WEST SUSSEX COUNTY COUNCIL CONSULTATION

TO:	Arun District Council FAO: Simon Davis
FROM:	WSCC - Highways Authority
DATE:	1 July 2019
LOCATION:	26 Burnham Avenue Bognor Regis PO21 2JU
SUBJECT:	BR/49/19/OUT Outline application with all matters reserved for 22 No. new dwellings consisting of 2 No. 1 bed dwellings, 18 No. 2 bed dwellings & 2 No. 3 bed dwellings. More information.
DATE OF SITE VISIT:	
RECOMMENDATION:	Advice
S106 CONTRIBUTION TOTAL:	£ N/A

Roof / Site Plan (Proposed) 1:200

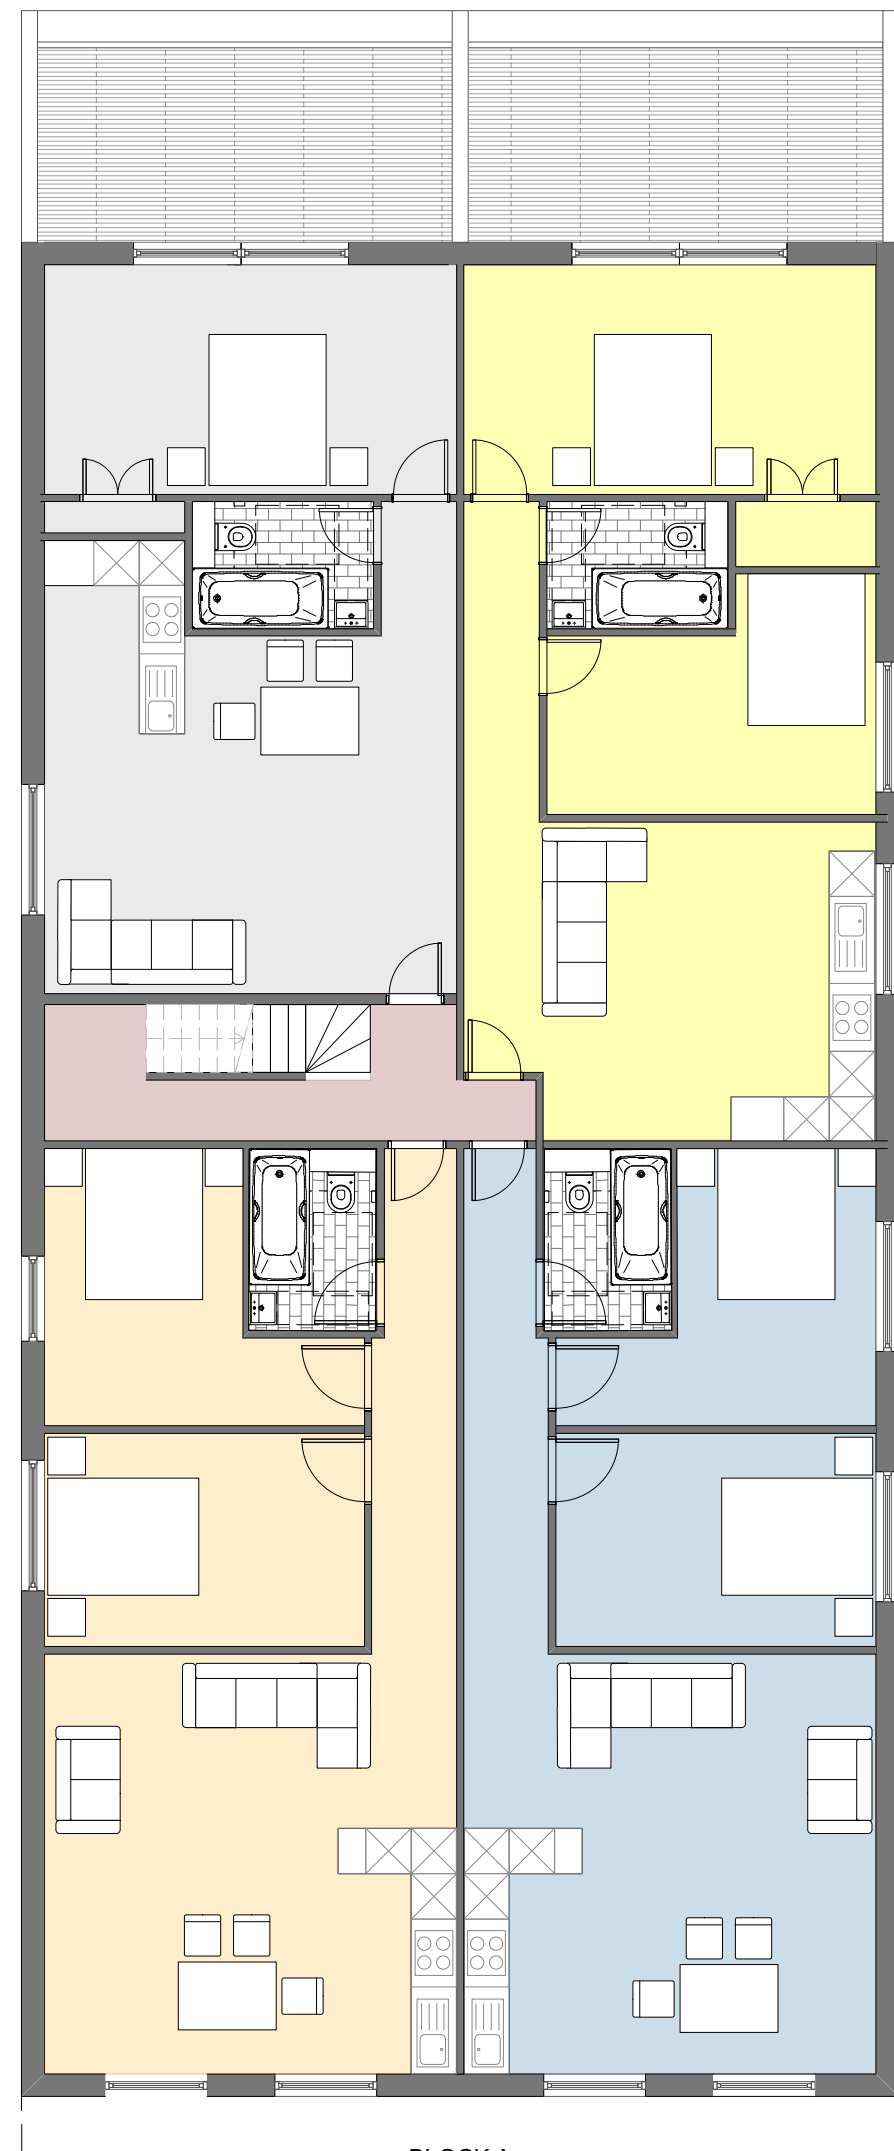
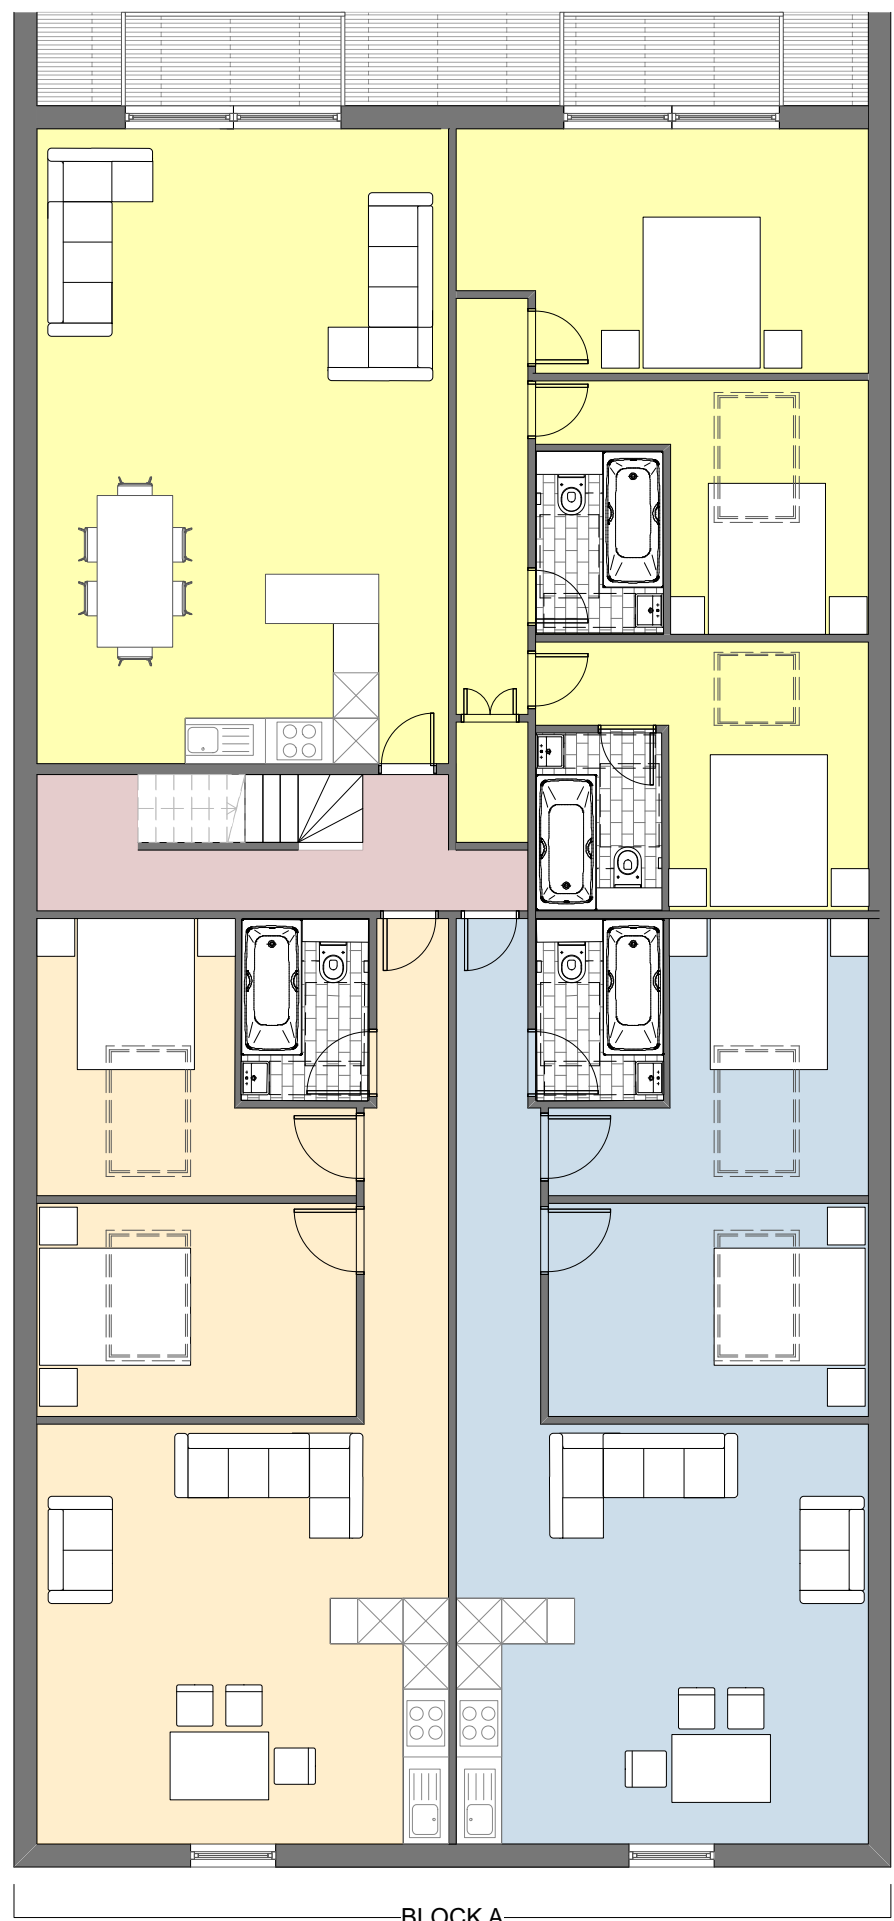
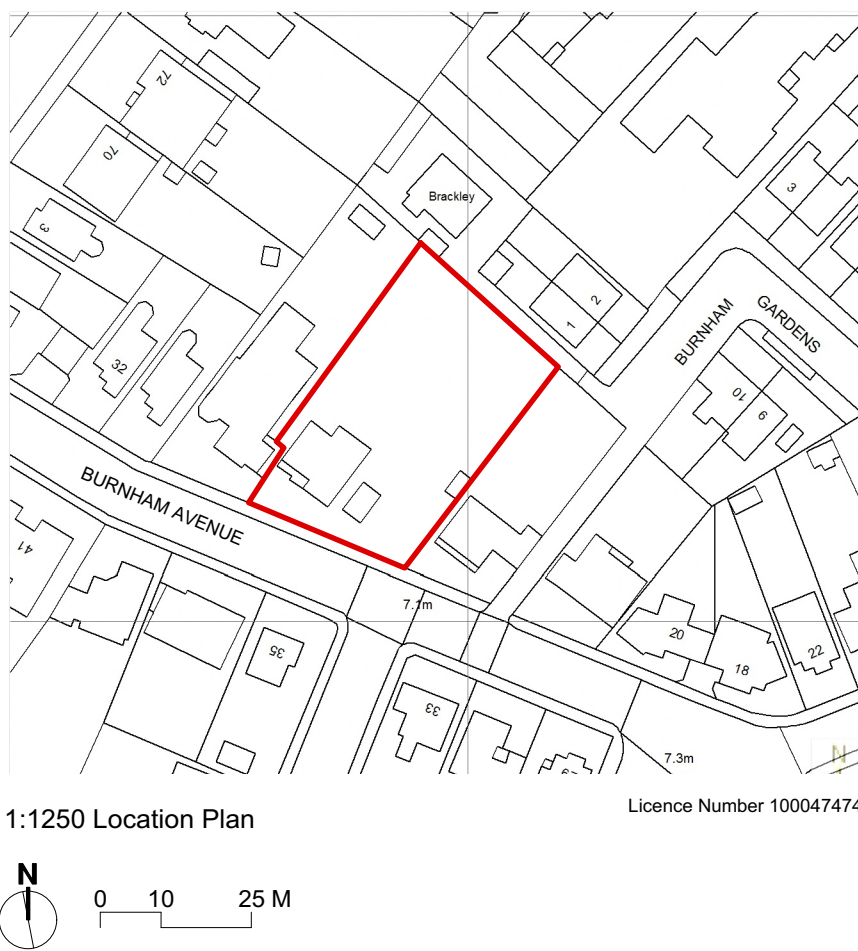
Secure and covered cycle parking has been shown and is supported by the LHA in order to alleviate the reliance on the use of a car. Given the sustainable location of the development and the proximity to the National Cycle Route no. 2 from Bognor Regis to Littlehampton it is considered that at a minimum of a single cycle parking space per unit would be sufficient to serve this development. I note that the current plans show 20 cycle parking spaces so at minimum we would expect two additional cycle parking spaces to be provided. These details can be provided at the reserved matters phase.

- Details of adequate cycle parking provisions at 1 space per dwelling
- Details of sustainable transport alternatives within the vicinity of the site
- Travel Plan Statements will be conditioned alongside any successful reserved matters or full application. The applicant may wish to provide this during the application process.
- Construction Management Plans will be conditioned alongside any successful reserved matters or full application. The applicant may wish to provide this during the application process.
- Plans demonstrating the closing off of the existing highways access
